**Consultation Response from KC,
Highways Development Management**
2021/91871 Land adj, High Street and Challenge Way, Hanging Heaton, Batley
Erection of residential development including access and associated infrastructure
Date Responded: 02-06-2021
Responding Officer: Mark Berry
Responding Ref: 15-12-26

This application seeks approval to the erection of a residential development (55 dwellings) including access and associated infrastructure at land adjacent to High Street and Challenge Way, Hanging Heaton, Batley.

CORSTORPHINE + WRIGHT
ARCHITECTS

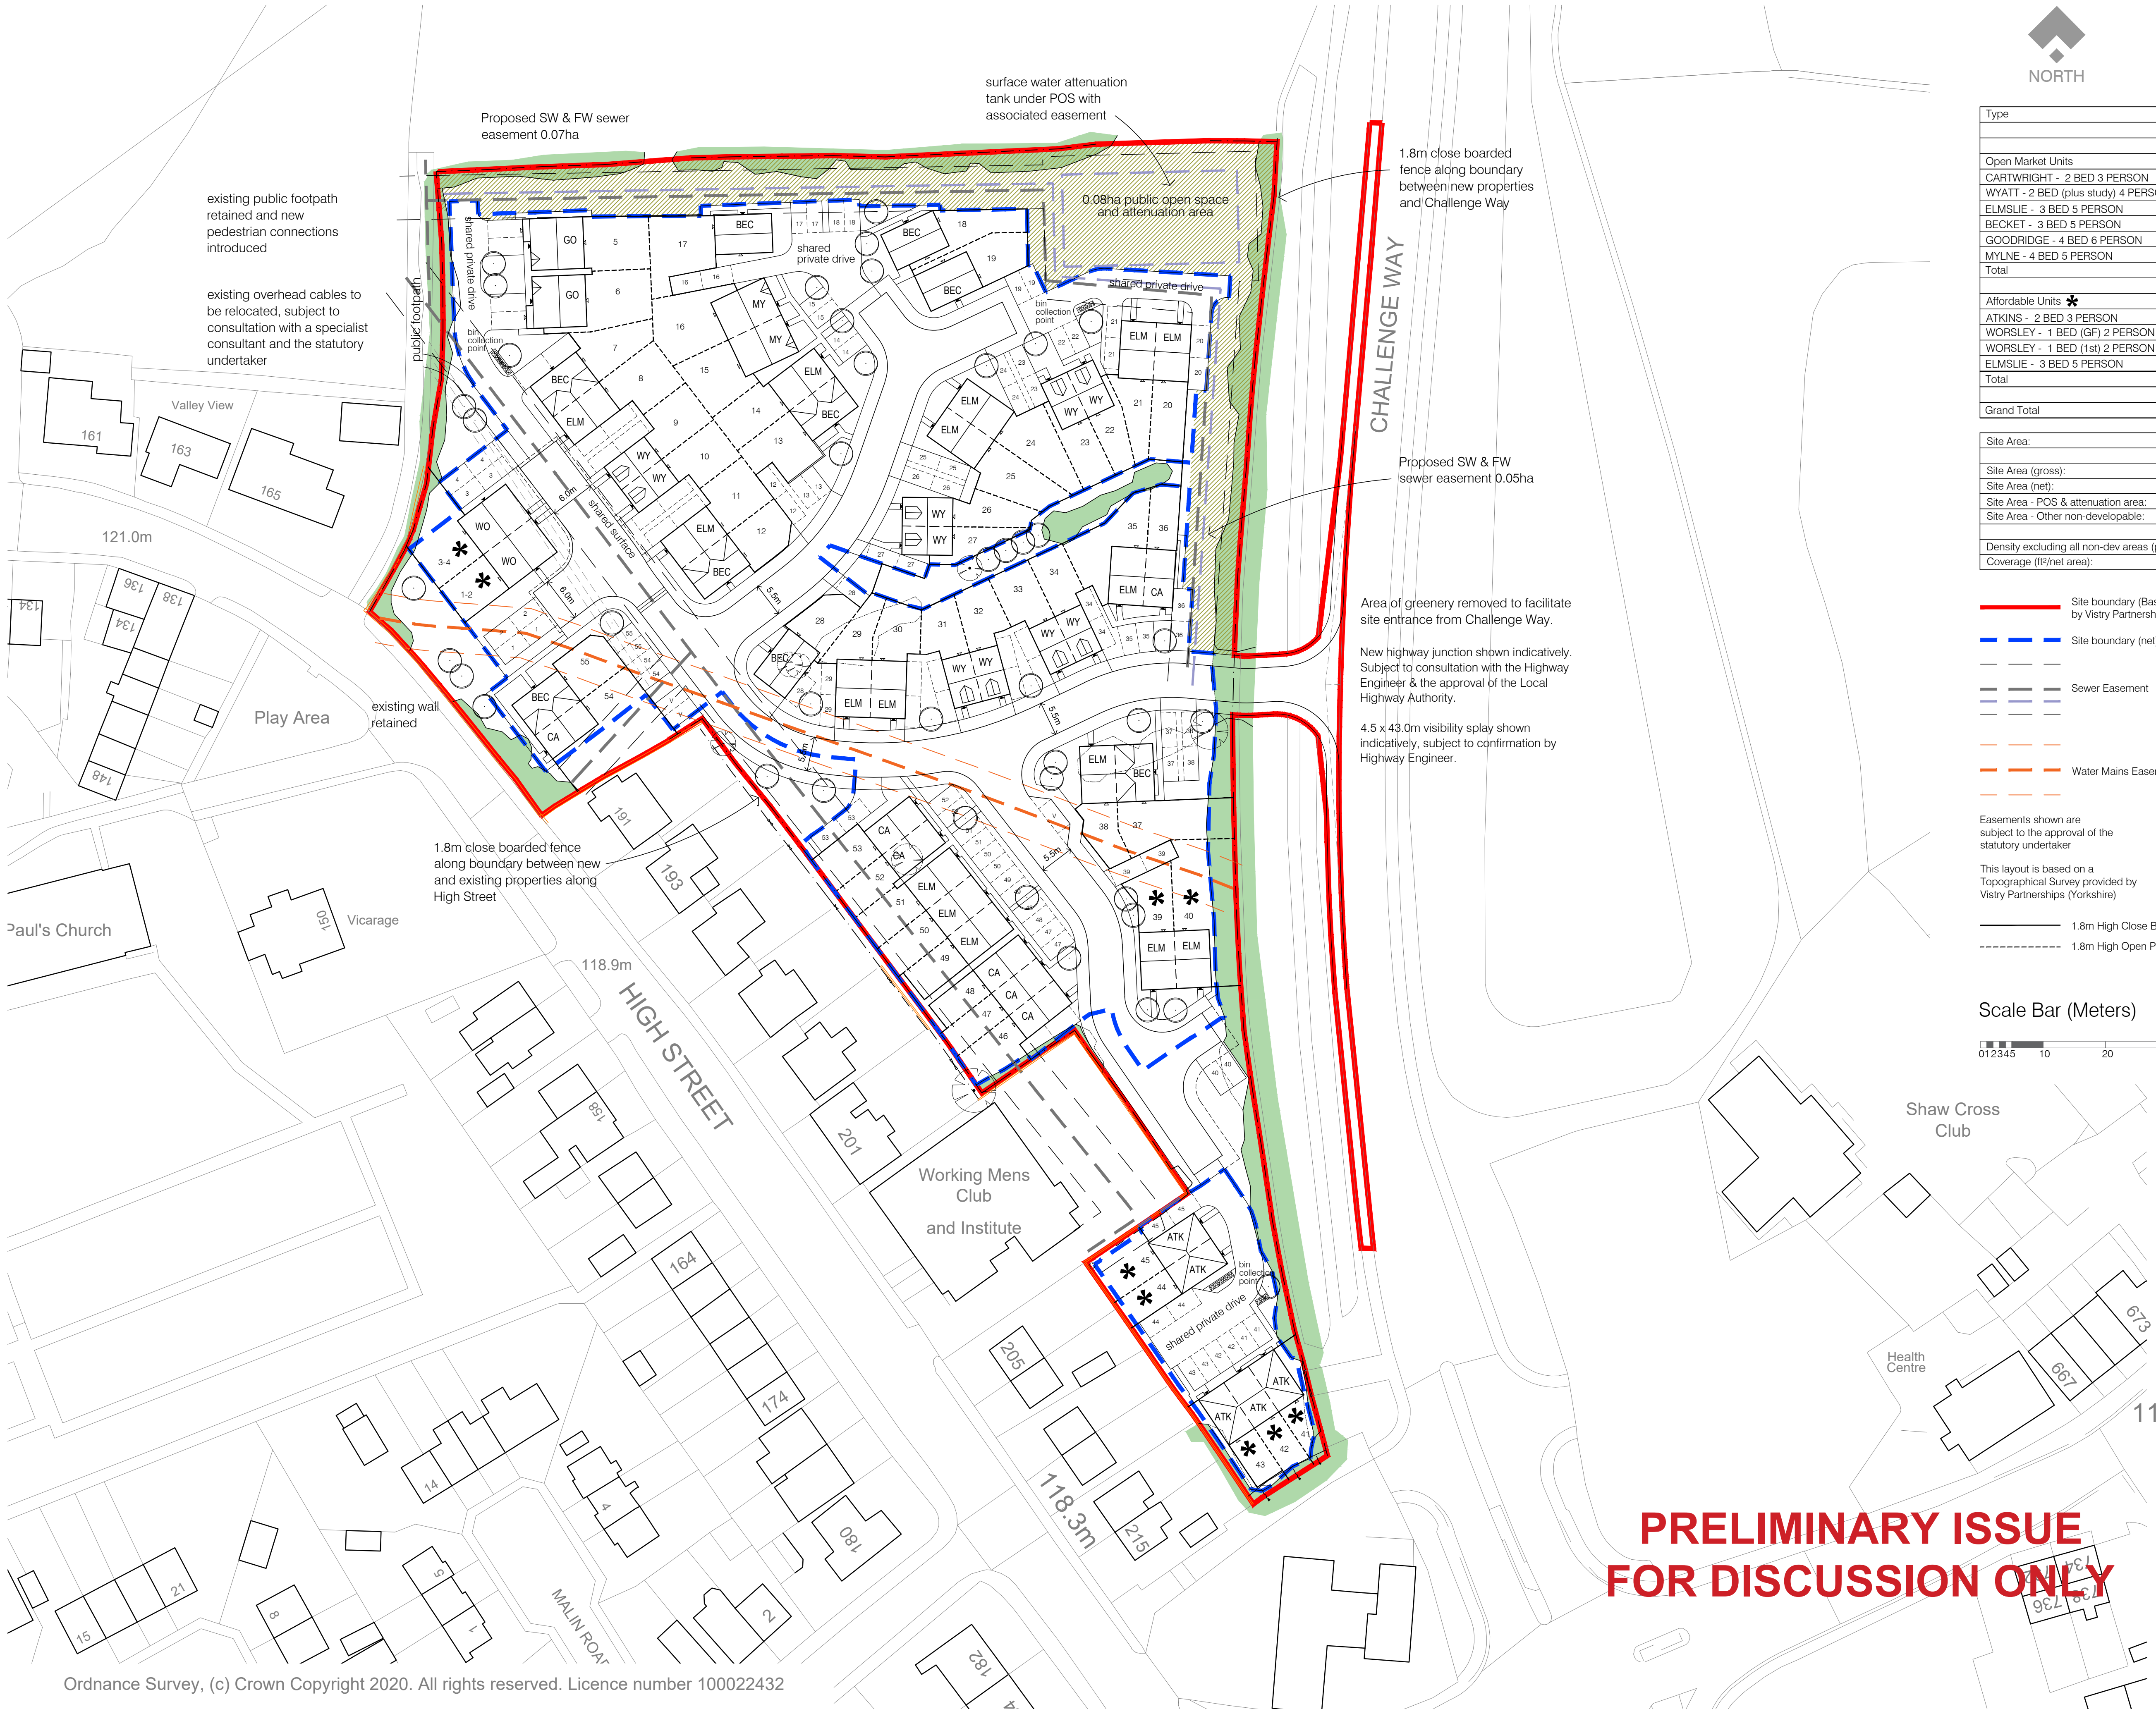
- 1, No right turn lane is shown to be provided along Challenge Way into the site.
- 2, The refuse vehicle swept paths are unclear and not all turning movements are shown. All turning movements should be shown clearly on separate plans. The swept path that are provided are shown close to kerb lines and appear to require stationary steering.

- 3, No sight lines are shown to any of the internal junctions.
- 4, No forward visibility splays are shown across any of the proposed bends.
- 5, No longitudinal sections are provided showing the gradients of the proposed roads.

- 6, The cul-de-sac serving plots 38 to 53 meets the main spine road at an angle, this should be turned to be perpendicular to the main spine road.
- 7, Shared private driveways should provide independent visitor turning spaces.

- 8, Visitor parking should be shown to be provided at a rate of 1 per 4 dwellings. This can be on-street along the traditional estate roads, but it shouldn't obstruct the refuse vehicle swept paths.

- 9, No sight lines are shown to the driveways to the first plots into the site plots 36 and 38.
- 10, Access to the parking spaces to plot 52 is across the junction radii.

- 11, There is very limited pedestrian access to plots 46 to 53.

12, Visitor parking shouldn't be provided perpendicular to the carriageway. These can't be adopted.

13, Access to the parking to plot 44 will be difficult and should be re-considered.

15, The shared driveways should be at least 4.5m in width at the access and 6.0m adjacent parking spaces to allow comfortable turning and manoeuvre.

18, 2.0m footways should be provided to all parts of the traditional estate roads and 600mm margins should be provided to all sections of the shared surface carriageways.
